RE: STATE SIGNIFICANT DEVELOPMENT APPLICATION (SSD 9601) FOR PROPOSED PLANT 2 UPGRADE WORKS

PROPERTY AT: 780 WALLGROVE ROAD, HORSLEY PARK (LOT 7 DP 1059698)

Following a review of the NSW DPIE's request for the Response to Submissions (RTS), dated 15 November 2019, the matters raised have been taken into consideration and are accurately addressed in the response matrix that is attached to this letter. It is considered, that this information now provides the NSW DPIE with all the necessary facts and relevant particulars related to the Proposed Development subject to this SSD Application; thereby, enabling the assessment to be finalised and the Proposal determined.

DRAWING TITLE
OVERALL SITE PLAN
 DATE AUG 2018 SCALE 1:2000@A3 1:1000@A1 JOB NO. 18212 DRAWING NO. DA 101A C

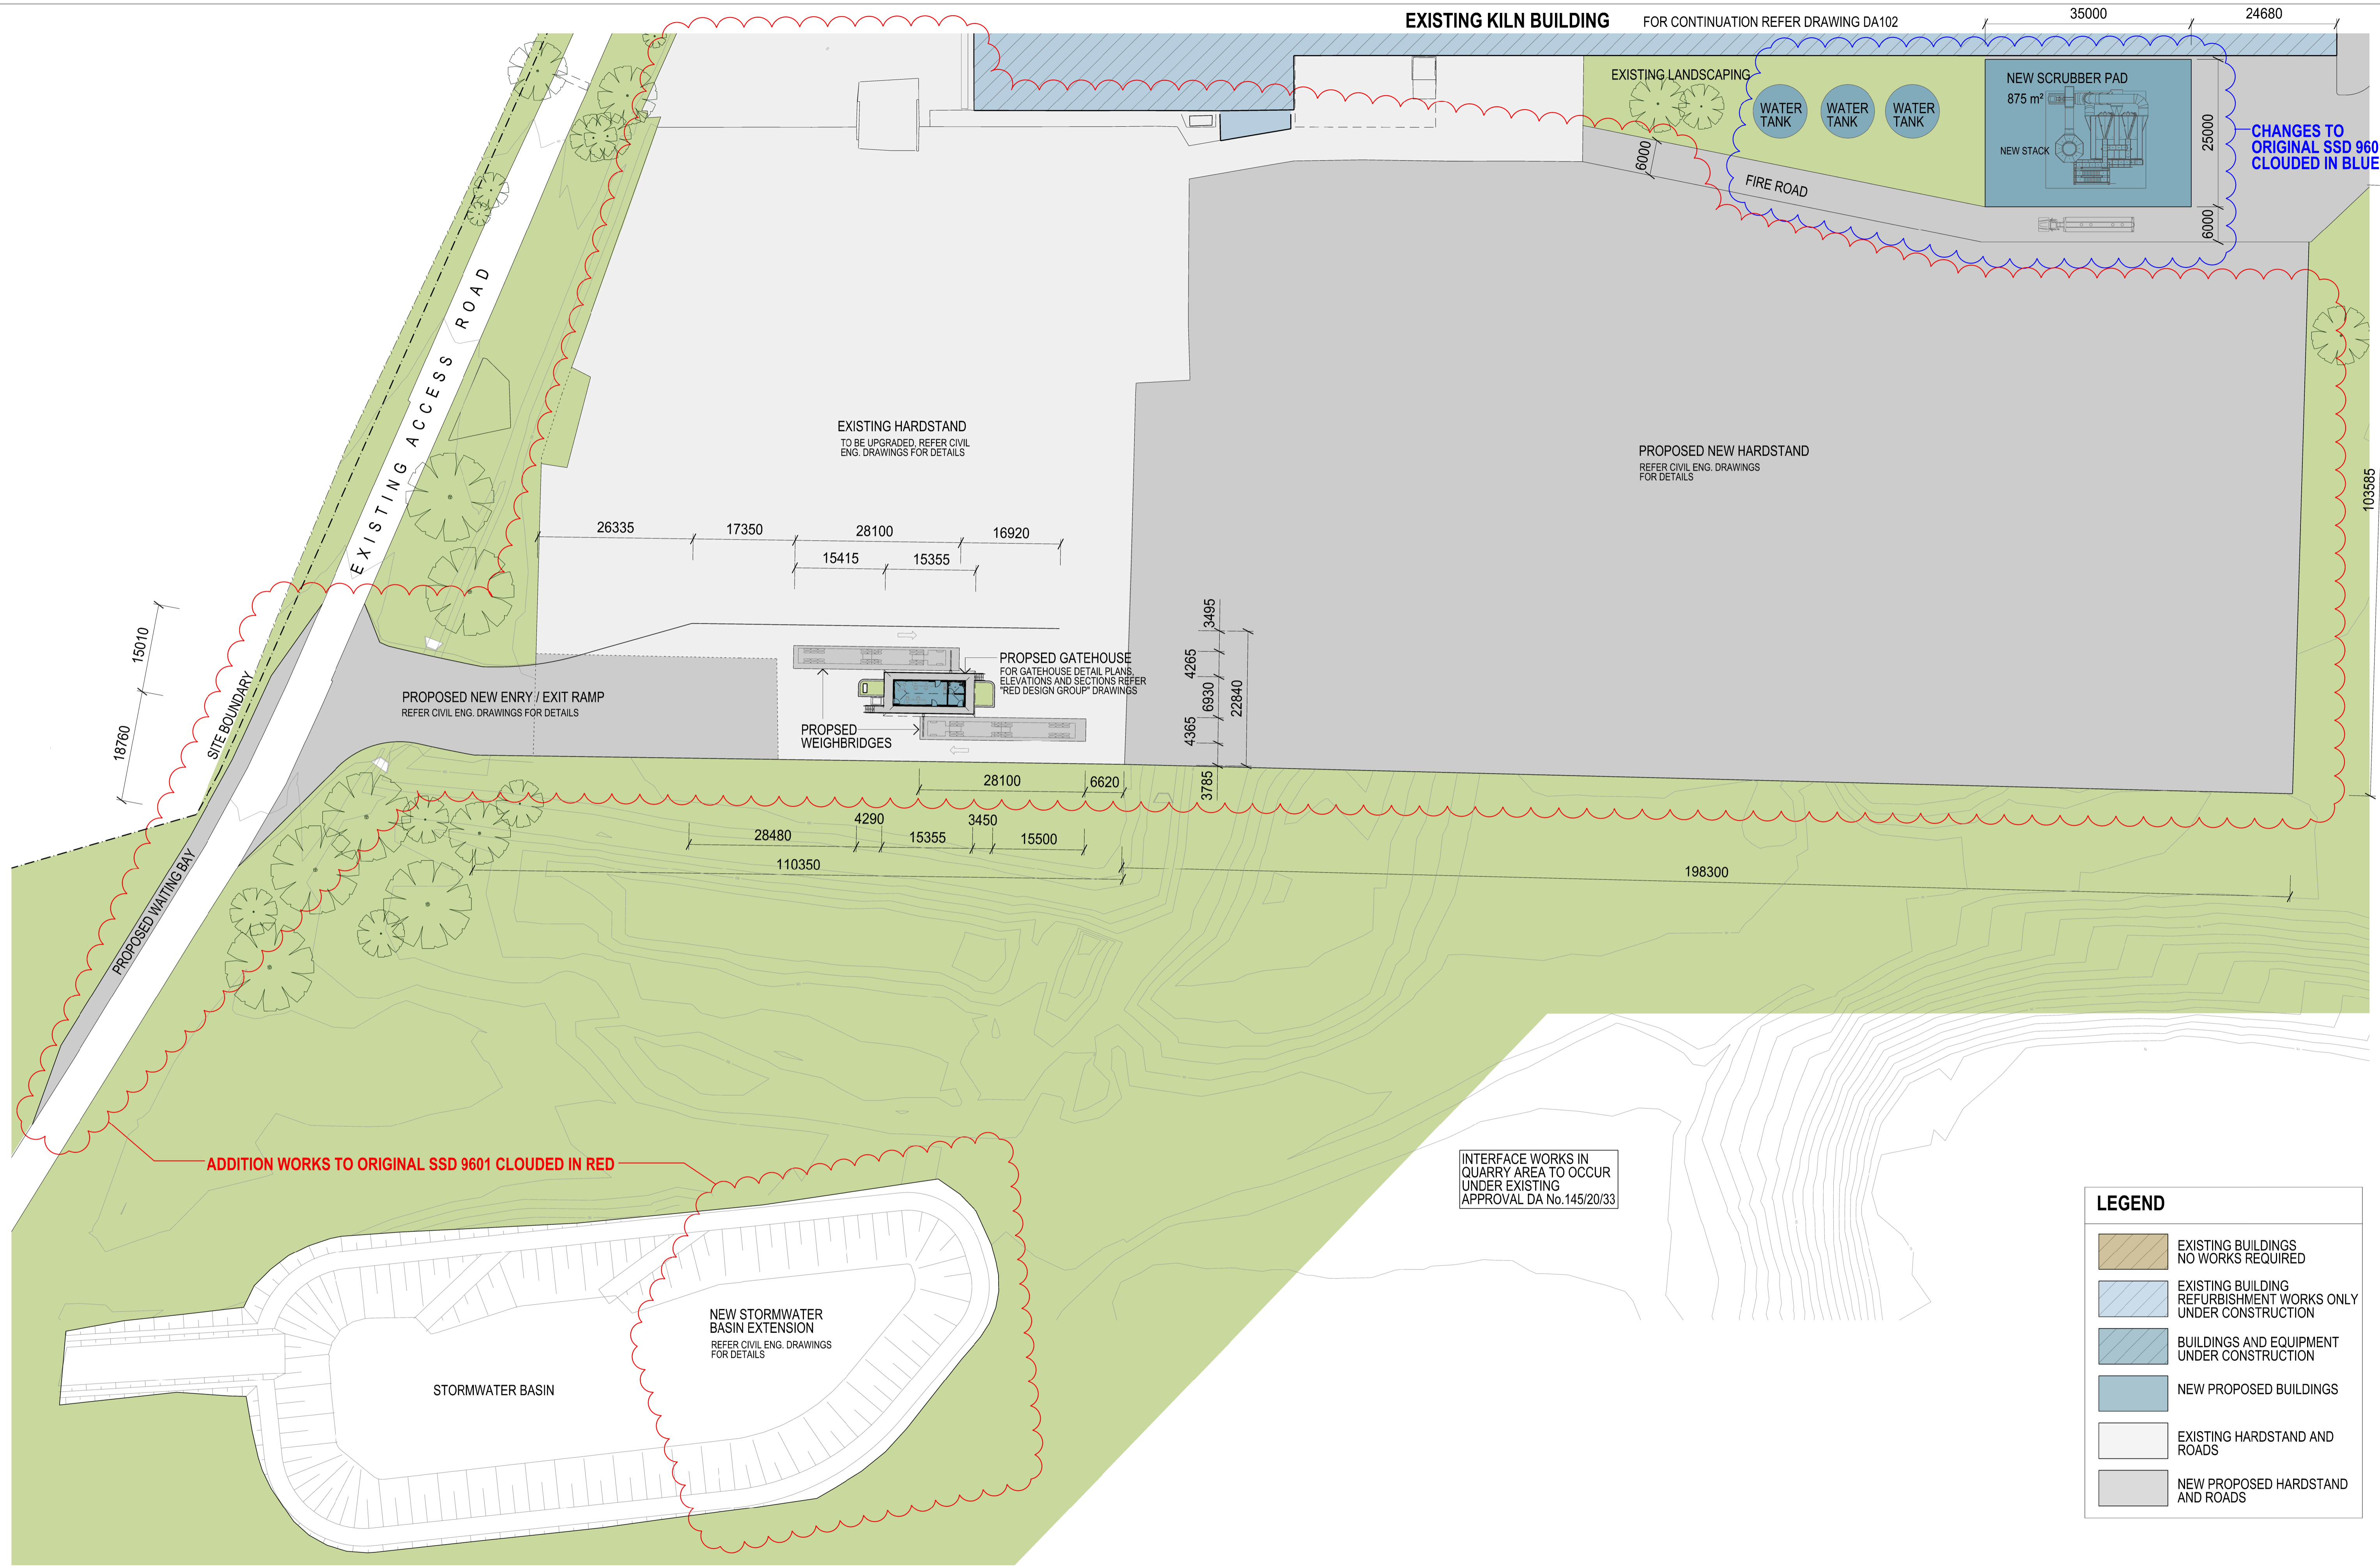
<p>Staff and Visitors Parking:</p> <p>Council notes that a large area of office space is proposed to accommodate the existing 35-onsite staff. The 18 car spaces proposed is not considered sufficient in accommodating existing office staff, production staff and maintenance staff and in this regard the proponent shall provide sufficient parking to accommodate the development.</p>	<p>Ason Group note, that the Site has historically been utilised for its existing brick-making purposes, for which the proposed development represents an upgrade to the existing operations, with respect to the facilities utilised on-site. No additional staff or traffic would be generated as a result of the proposed development.</p> <p>Noting the Traffic Impact Assessment prepared for SSD 9601 by Ason Group, it is noted, that all existing car parking is provided in an unmarked car parking area in the northern portion of the Site, for which the design and use of this car parking area is consistent with past approvals and the development history of the Site.</p> <p>A technical assessment of the unmarked car parking area was undertaken to ensure</p>

<p>that the car park provides appropriate capacity when measured against the appropriate Australian Standards. This assessment indicated that the car park can effectively provide for up to 63 car parking spaces based on the minimum requirements of AS 2890.1 and well over 50 car parking spaces where vehicles are not parked efficiently.</p> <p>Furthermore, it is proposed to provide 18 formal spaces in addition to the existing car parking scenario for the purposes of formal visitor parking.</p> <p>Additionally, the proposal seeks to retain staff numbers (35 staff in total), which would result in a parking demand of 35 spaces in a worst-case scenario. As such, the provision of 63 spaces will account for the anticipated parking demand for the proposal.</p> <p>Accordingly, the parking demand for the proposal is considered satisfactory. The letter of support prepared by Ason Group (2019) is located within Appendix 4.</p>
